Town & Country Planning Act 1990 (as amended)
Town and Country Planning (Development Management Procedure) (England) Order 2015
Application for approval of details reserved by conditions imposed on planning reference
BR/270/16/PL relating to condition no. 3 (Drainage), 4 (Arboricultural Protection Measures) & 6
(Materials & Finishes)
Villa Maria Campbell Road, Bognor Regis,

Notification regarding the above application:

Decision:

Proposed Material Elevation

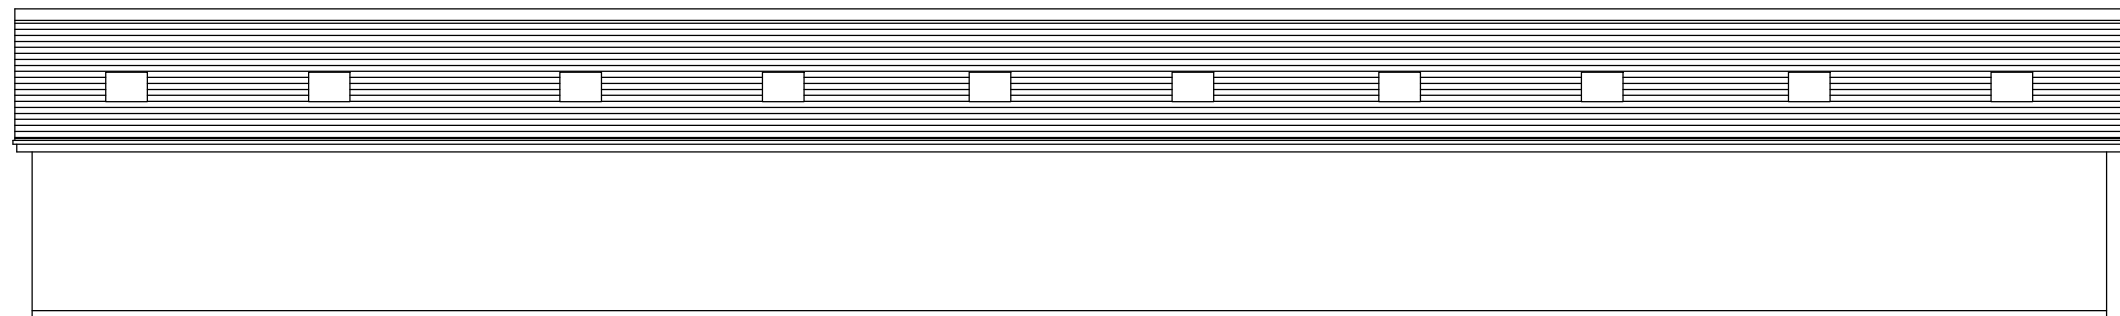
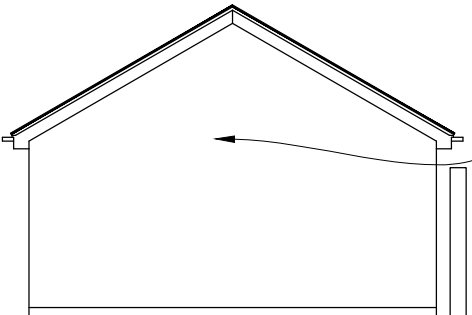
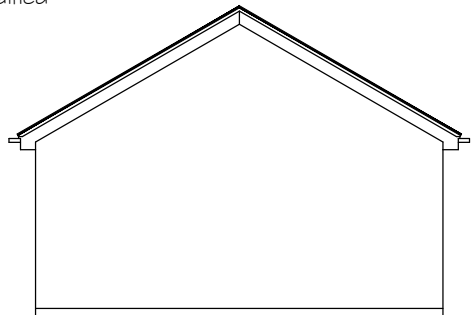
Plan 160035 Drg.No 22 Proposed Material Elevation dated 18/07/17 details as follows (1) External Walls - Render (blue) (2) Roof - Marley Modern Interlocking Concrete Tile (Grey) and in accordance with the colour photographs submitted with the application.

These are considered to be acceptable having regard to the character and appearance of this urban locality and of the host building itself.
